PLANNING CONSULTATION RESPONSE

Application No	2025/0797
Proposal	Demolition and re-build of existing house with associated work to boundary walls (custom/self build)
Address	Berry Well, Kirkwood Bridge Lane, Spring Vale, Sheffield, S36 6AX
Date of Consultation Reply	8 th December 2025
Consultee	Highways DC

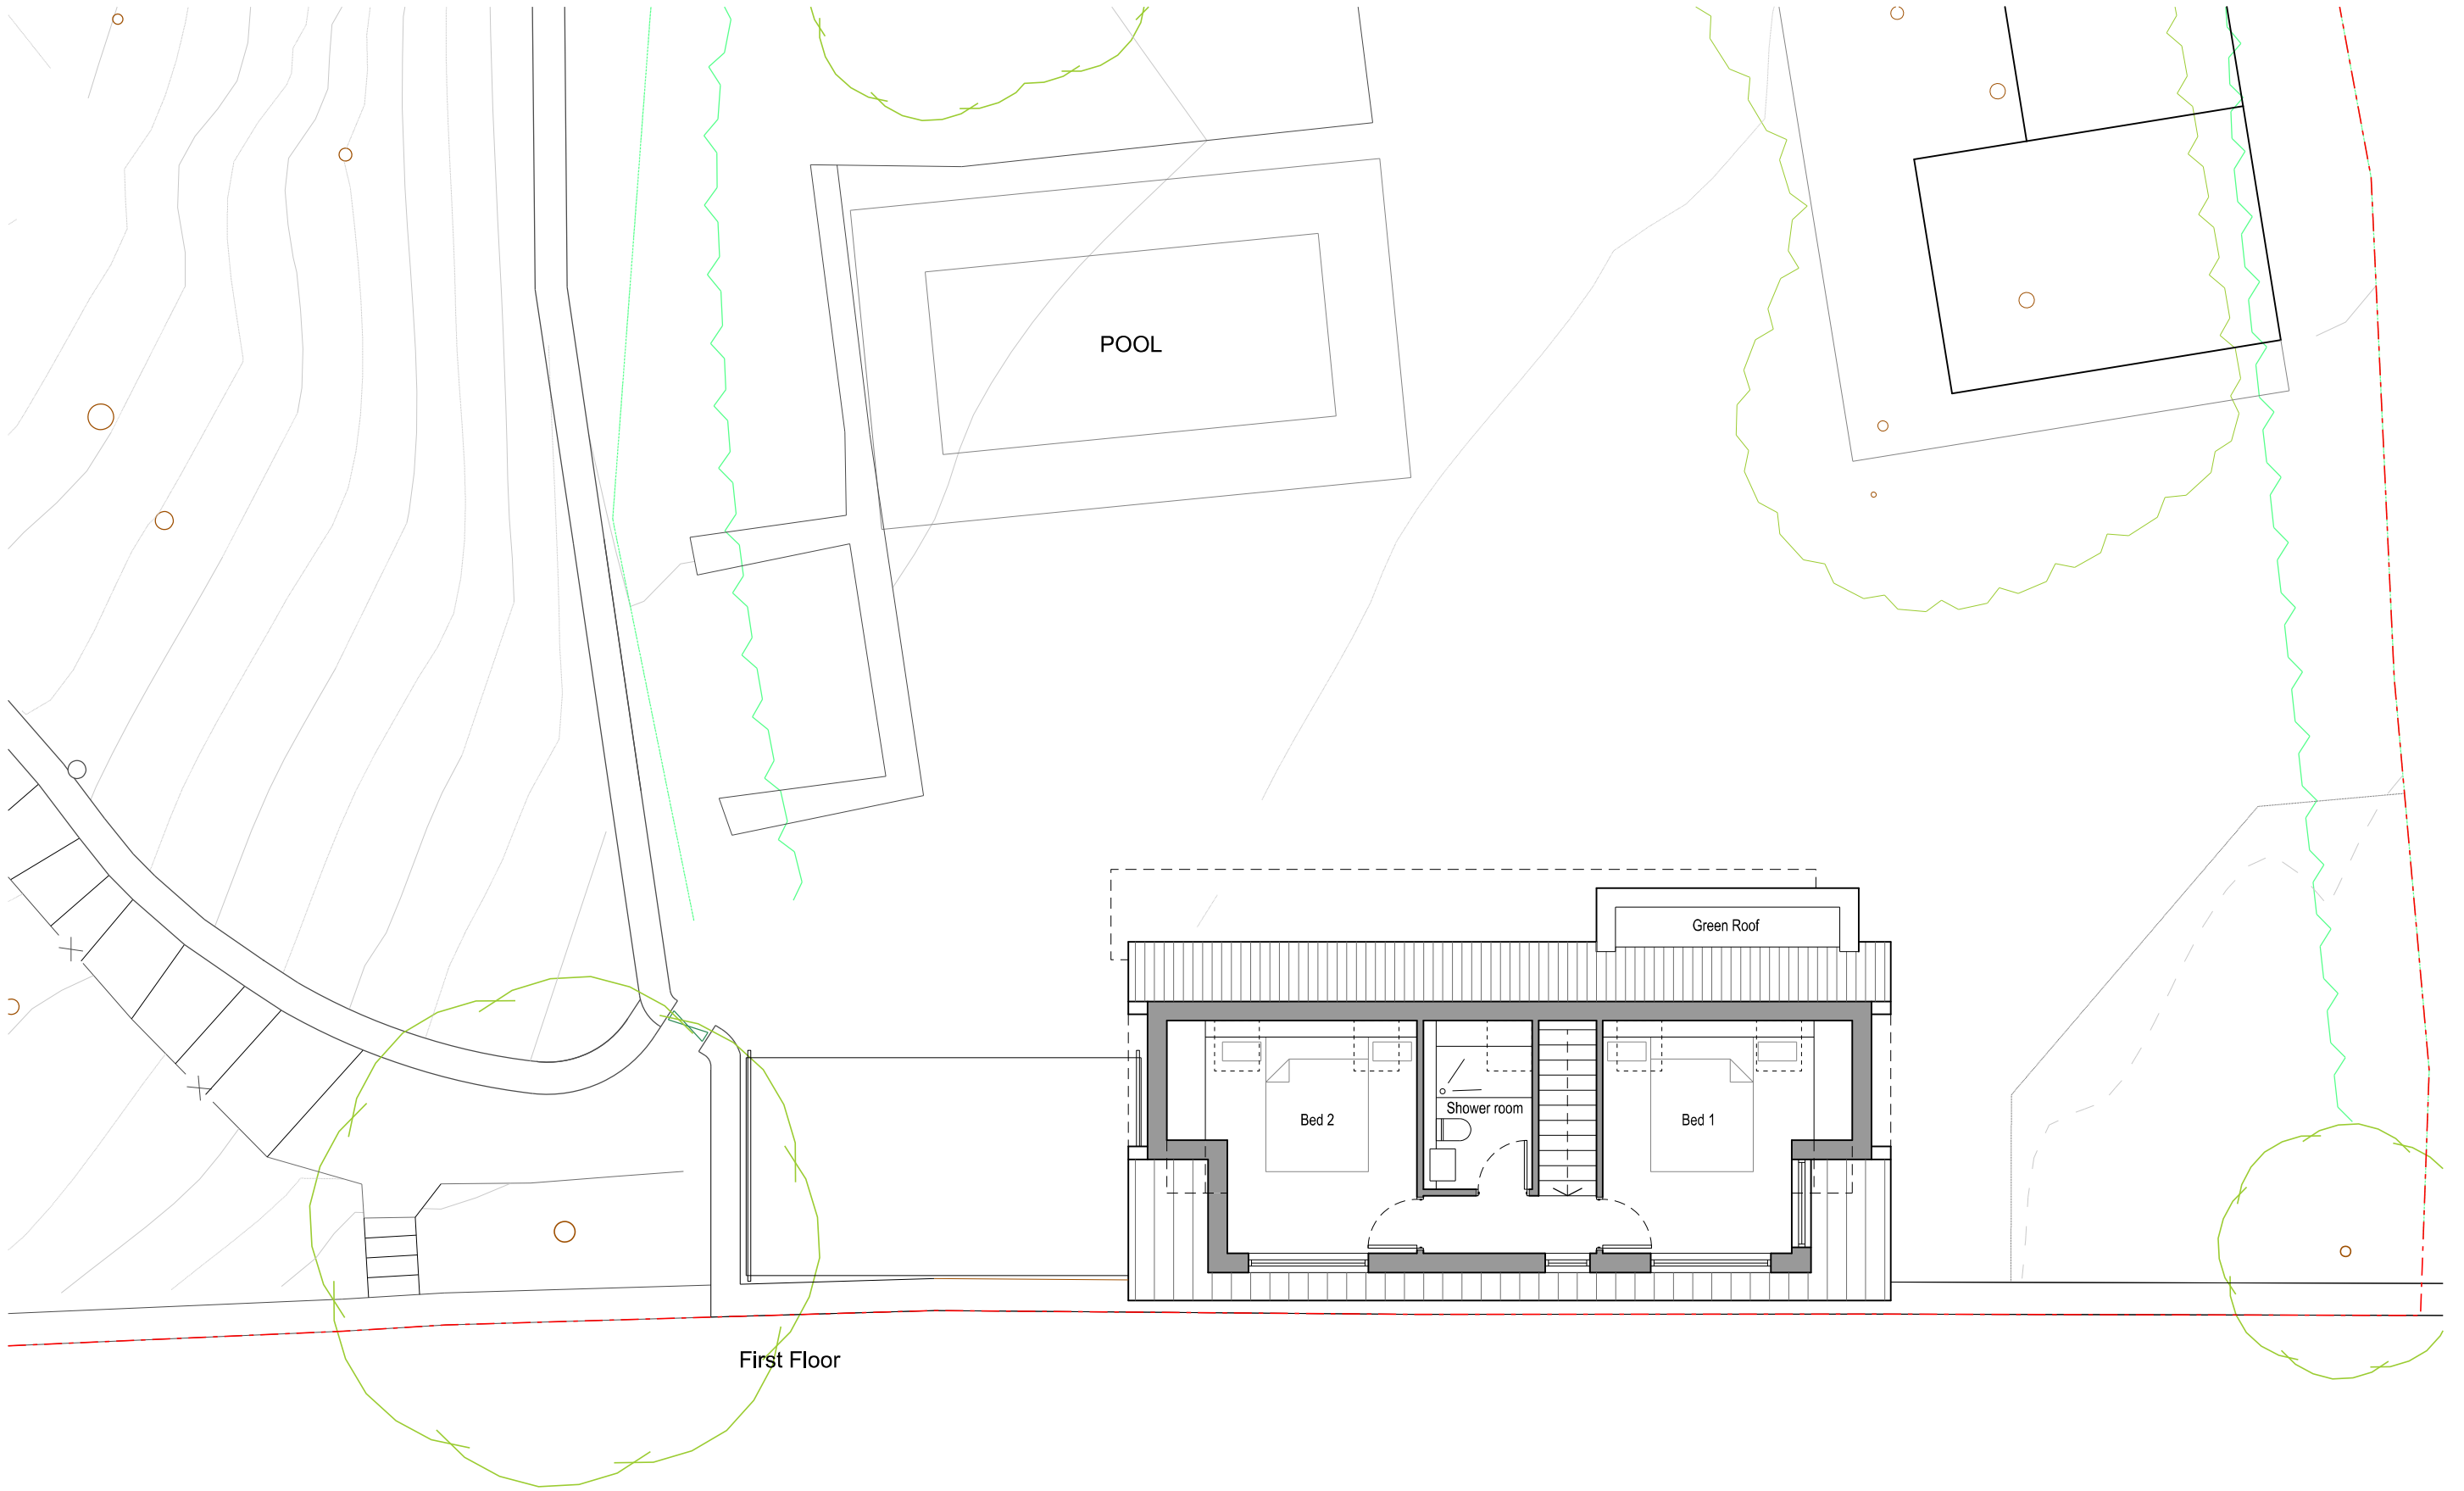
The proposals involve the demolition of the existing dwelling and the erection of a replacement dwelling, as such, there would be no intensification of use of the site access. It is stated within the submitted information that there are two parking spaces within the site and that these are to remain; it is noted though that the spaces do not appear to be indicated on the submitted plans.
